MECKLENBURG COUNTY  
Park and Recreation Department

MEMORANDUM

**RE:** Rezoning Petition #2022-018  
PID# 02933106

JOB NO.
50424
SHEET NO.
RZ-1.0

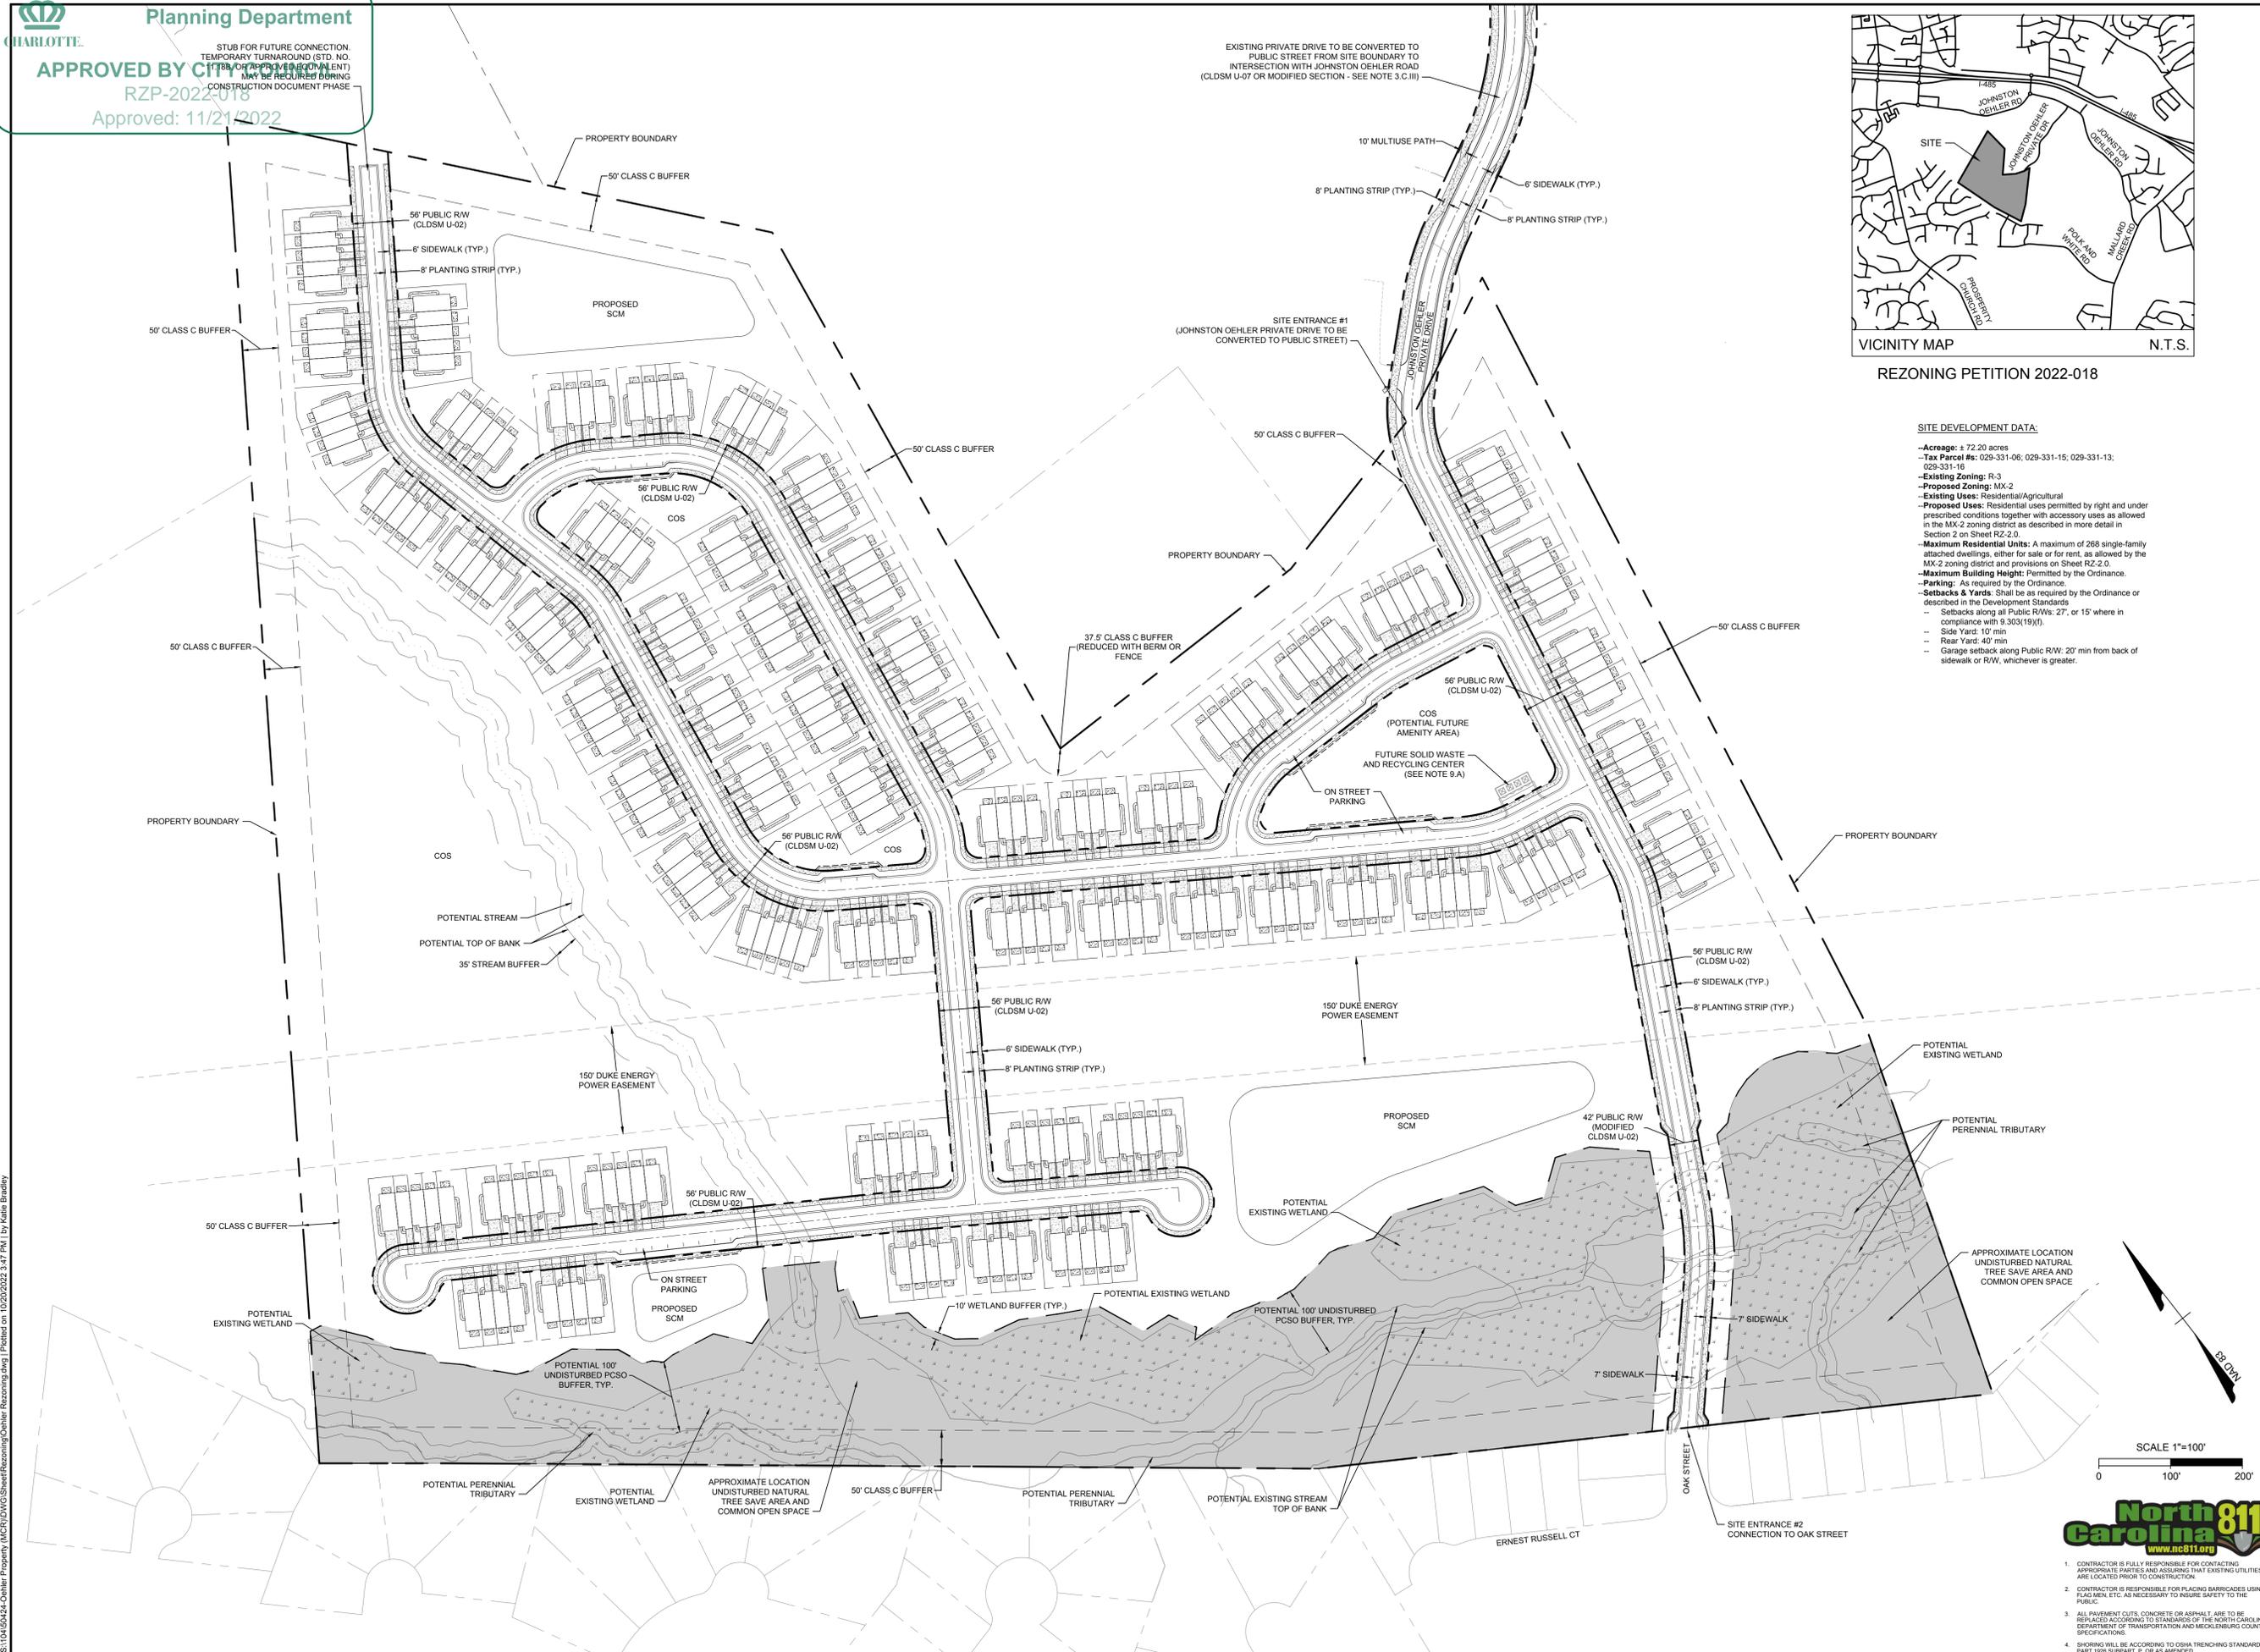
MCPR does not support the proposed vehicular access through County-owned park property.
